**Planning Application, Ribble Valley District
3/12/0524 Holden Wastewater Treatment Works, Bolton By Bowland**

I refer to your letter of 25 June 2012 concerning the above application.

**PROPOSED PLAN**  
Scale 1:200

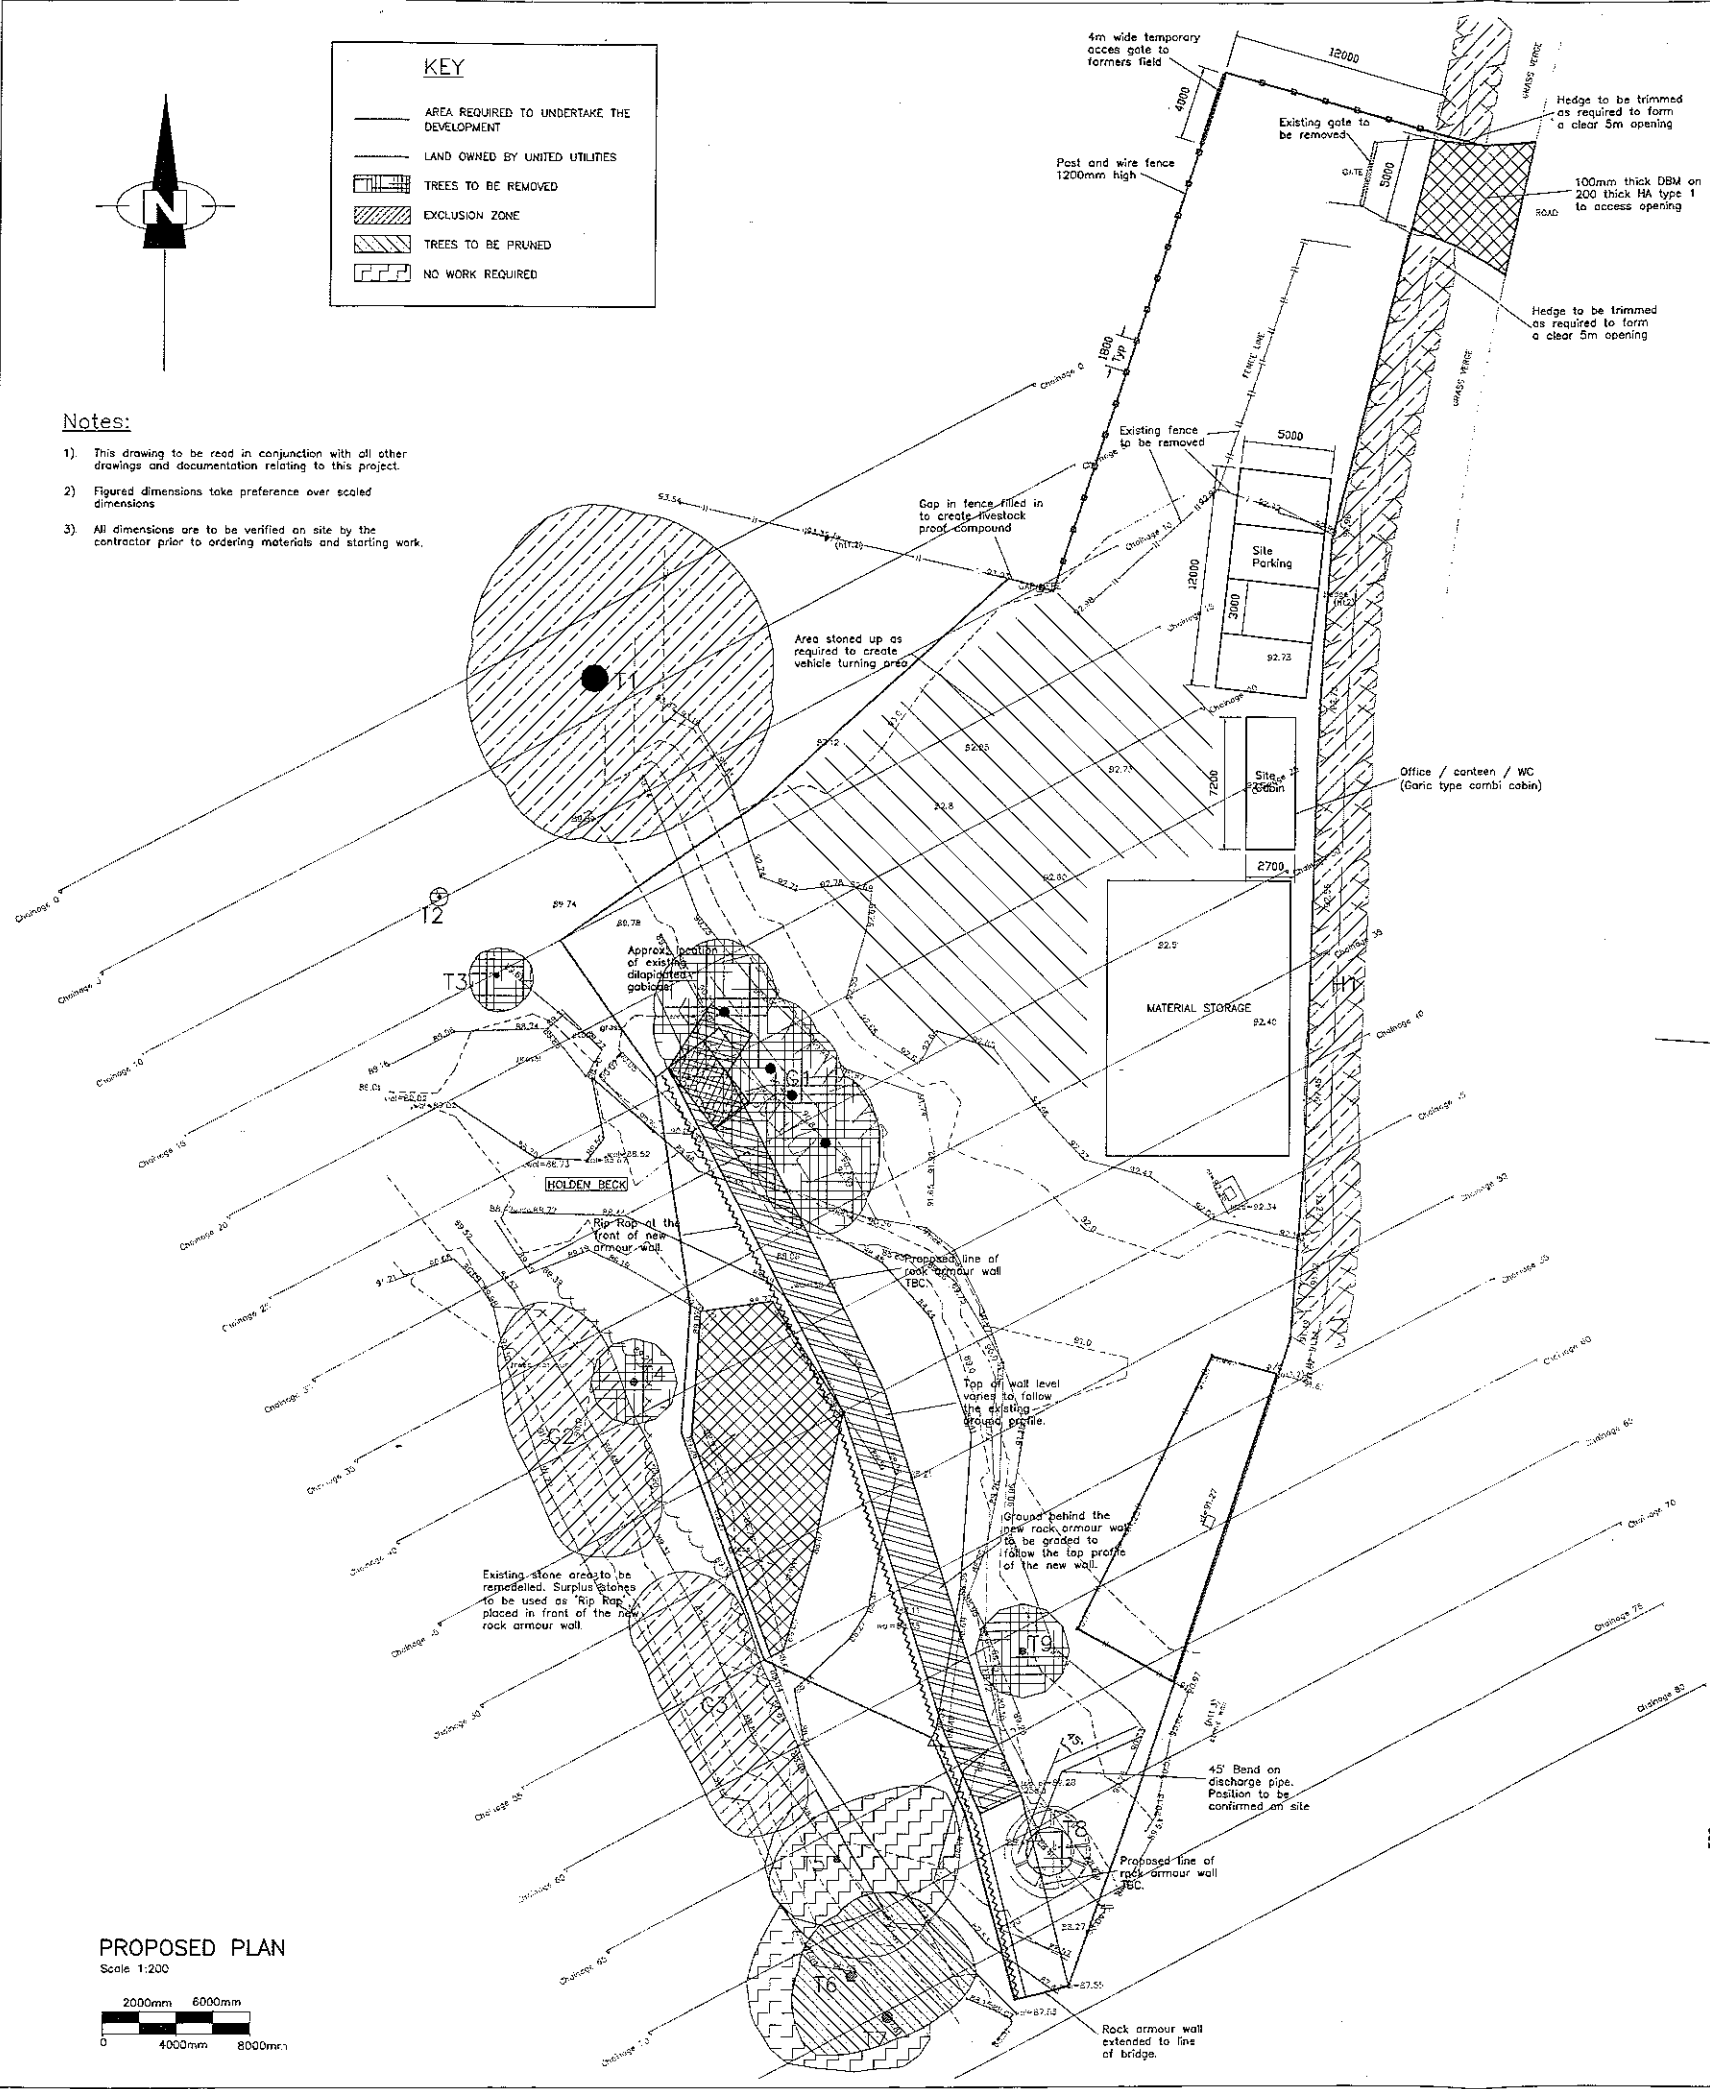
The proposed temporary widening of the access must be returned to its original condition following the completion of the utility work for the water supply pumping station.

Should consent be granted for this application, I would welcome a Condition requiring the applicant to inform Lancashire County Council of the detailed scheduling for the completion of the remedial works.
